## ASSESSMENT REPORT

### MIRANDA DENTAL HOSPITAL MP 11\_0009 (MOD 3)

This report is an assessment of a request to modify the Project Approval MP 11\_0009 for the Miranda Dental Hospital at 84-86 Kiora Road, Miranda. The request has been lodged by PPD Planning Consultants on behalf of Russo Family Trust (the Proponent), pursuant to Section 75W of the *Environmental Planning and Assessment Act 1979* (EP&A Act). It seeks approval to increase the building height, reduce the number of car parking spaces, amend the access arrangements, erect additional signage and various other internal and external design amendments.

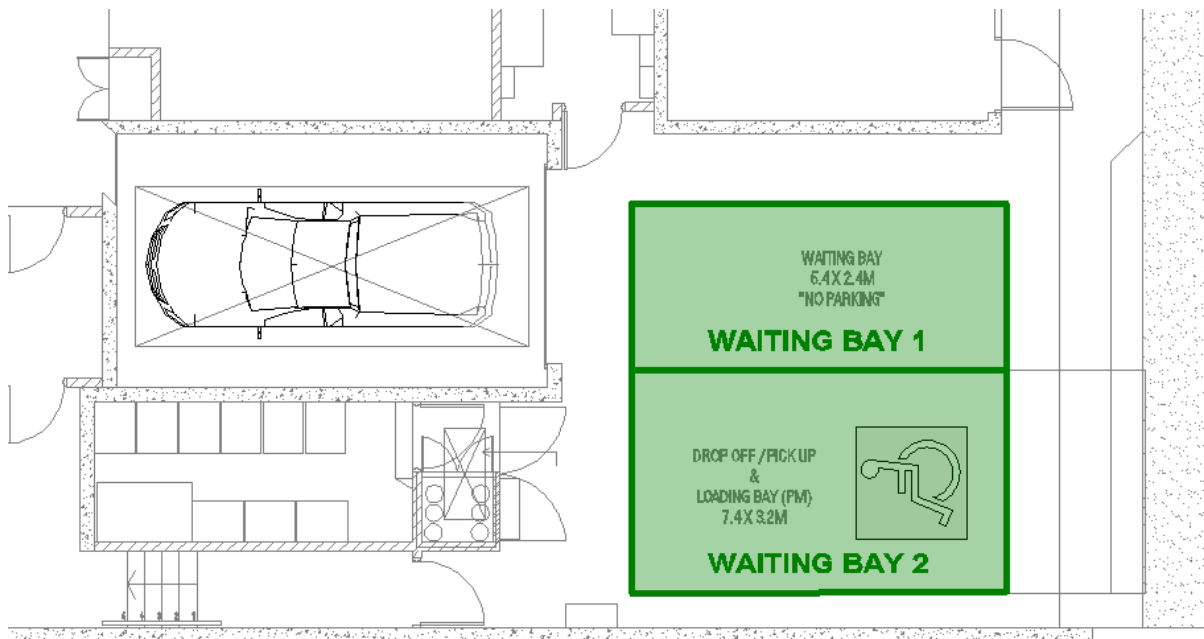
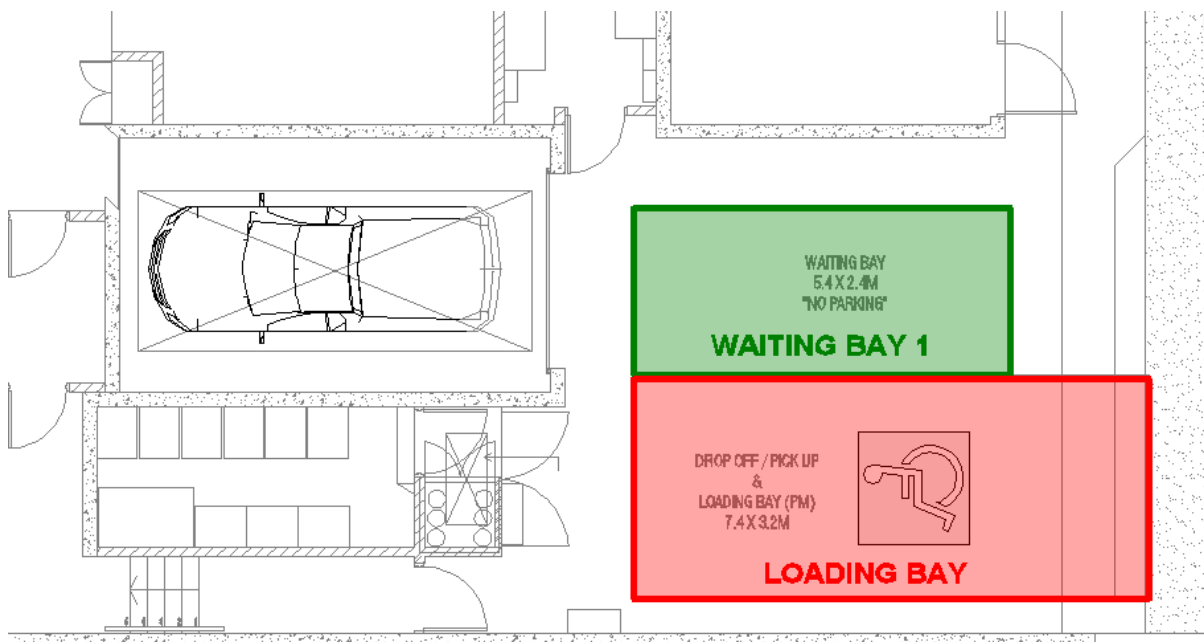
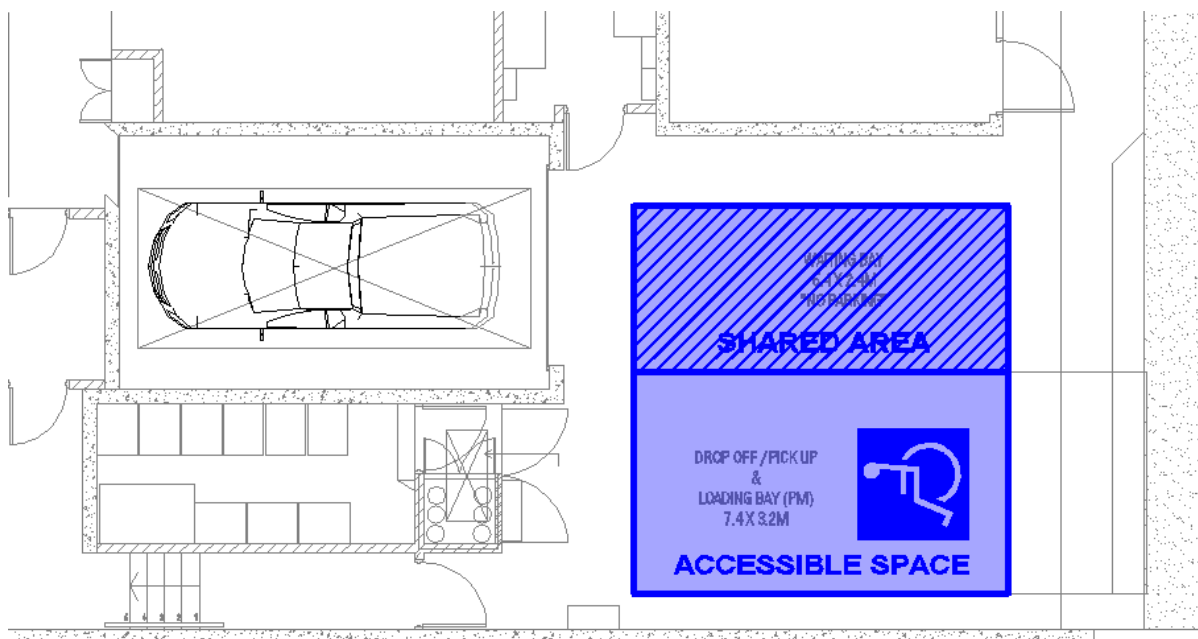
Council has raised concerns with the plans showing the disabled car space being shared with a loading bay and considers the disabled car space should remain free and accessible at all times.

The Department considers the proposal would provide appropriate access for persons with a disability in accordance with relevant requirements, noting a valet would be on site to assist patients and to manage other vehicle movements. However, the Department does not support restricting the hours where patients with a disability can make appointments and considers such a restriction to be unreasonable. A condition is therefore recommended requiring the OTMP to be updated to remove this restriction, so that persons with a disability can access the facility at any time during normal patient hours. A condition is also recommended requiring an update of the OTMP to include management protocols to enable staff members with a disability to work at the site and access the carpark. In addition, a condition requiring signage within for drivers entering the site, outlining the waiting arrangements is recommended.

In response, the Proponent has confirmed the space would be used as a drop-off/ waiting bay only and not a disabled parking space, but it would allow for people with a disability to be dropped off. The space would also be used as a loading bay for service vehicles after patient visitor hours, between 4:30 pm - 9:00 pm.

The Proponent also submitted an Access Report to assess the proposed use of the drop-off/waiting bay as a drop off space for disabled persons against the Building Code of Australia (BCA) 2016, Disability Standards and relevant Australian Standards. The report confirms accessible parking is not required in a car parking area where a parking service is provided and direct access to any of the car parking spaces is not available to the public. The report also confirms there is sufficient space in the driveway for drop off of accessible vehicles including those fitted with a rear loading ramp or hoist for a wheelchair.

BASEMENT LEVEL
**39 FULLY AUTOMATED PARKING SPACES OVER THREE LEVELS
 WITH INTEGRATED ACCESSIBLE PARKING VIA VALET ASSISTED
 TRANSFER AT ENTRY. REFER TRAFFIC ENGINEERING REPORT**

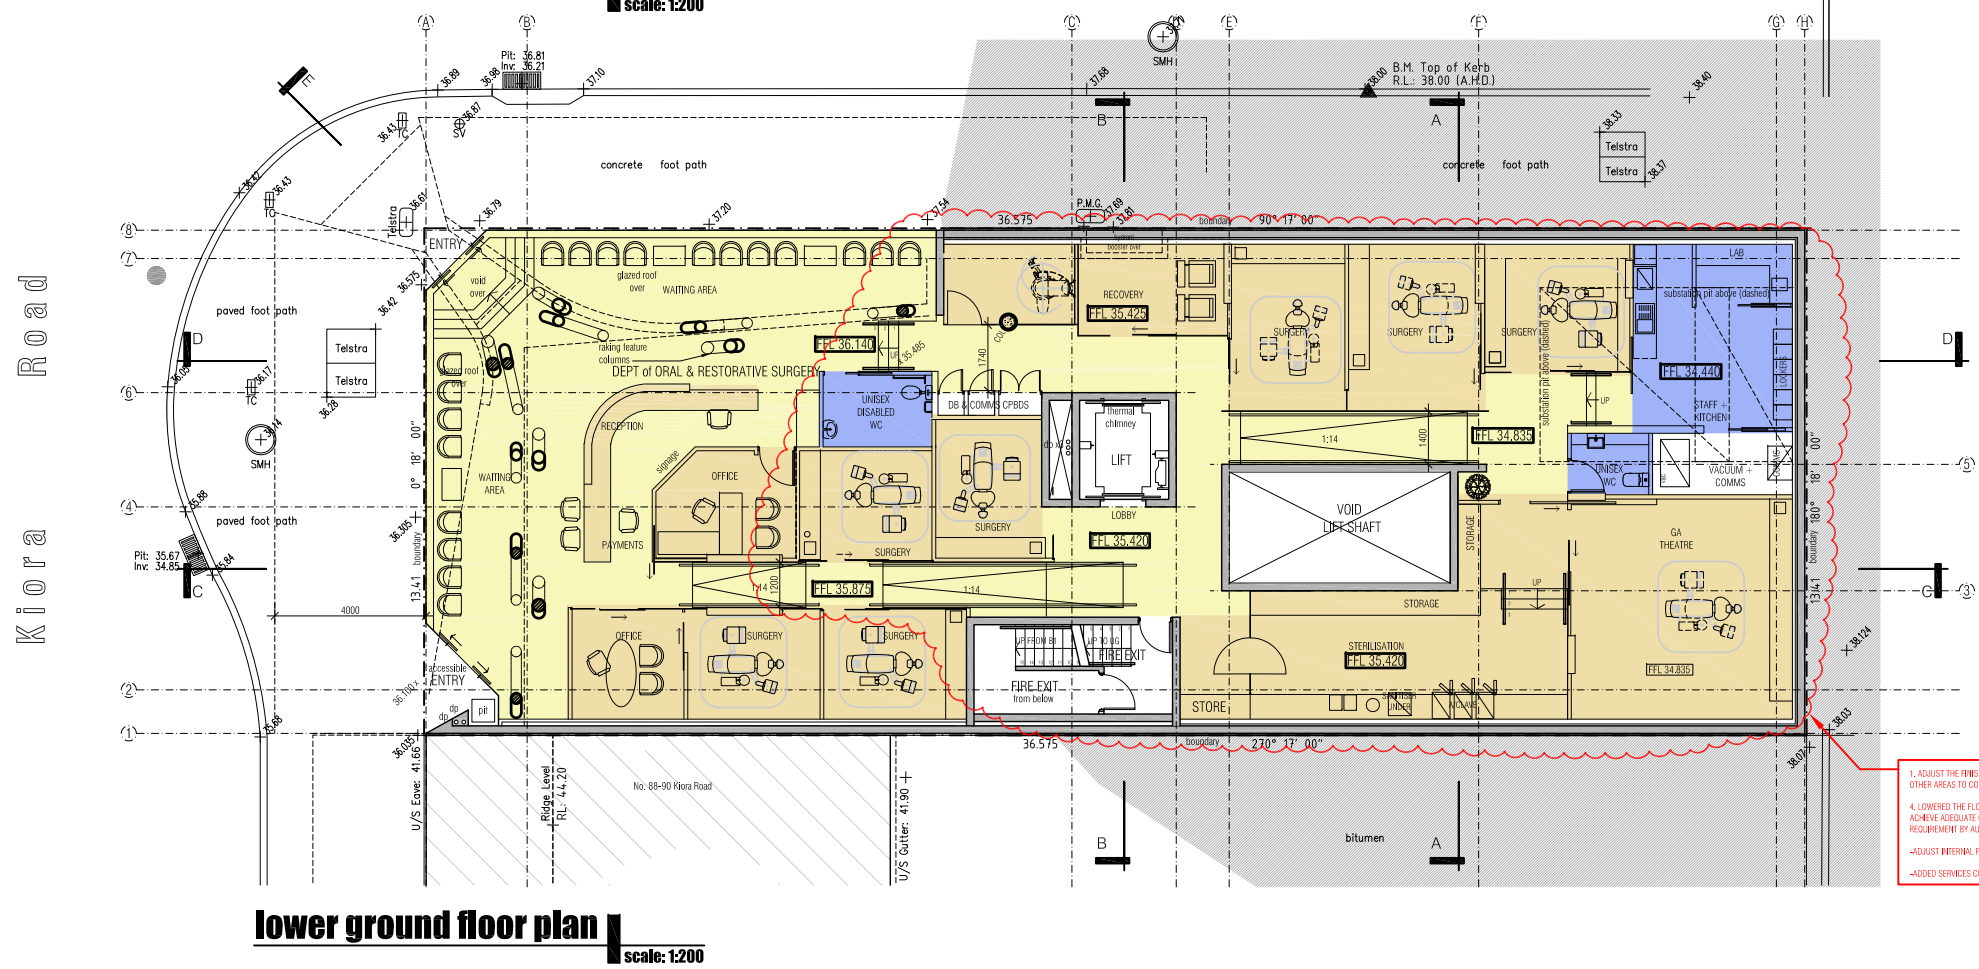
Council object to the proposed reduction in car parking as it considers the proposal is already deficient in on-site parking and there is a significant shortage of on-street parking in the vicinity

The Department considers the proposed reduction of two on-site parking space is acceptable for the following reasons:

- the reduction of two car parking spaces is considered to be minor (representing a 5% decrease);
- the site has excellent access to public transport, with Miranda Train Station located 50 m away from the site;
- the change to the staff car parking is minor and remains at the same rate as originally assessed (1 space per 3 staff) after calculations are rounded;
- on site bicycle storage facilities are provided for staff; and
- visitor parking would be carefully managed by the operator through an OTMP, which requires:
  - parking being made available by reservation only;
  - patients being made aware of the parking arrangement when booking their appointment; and
  - provision of a valet service.
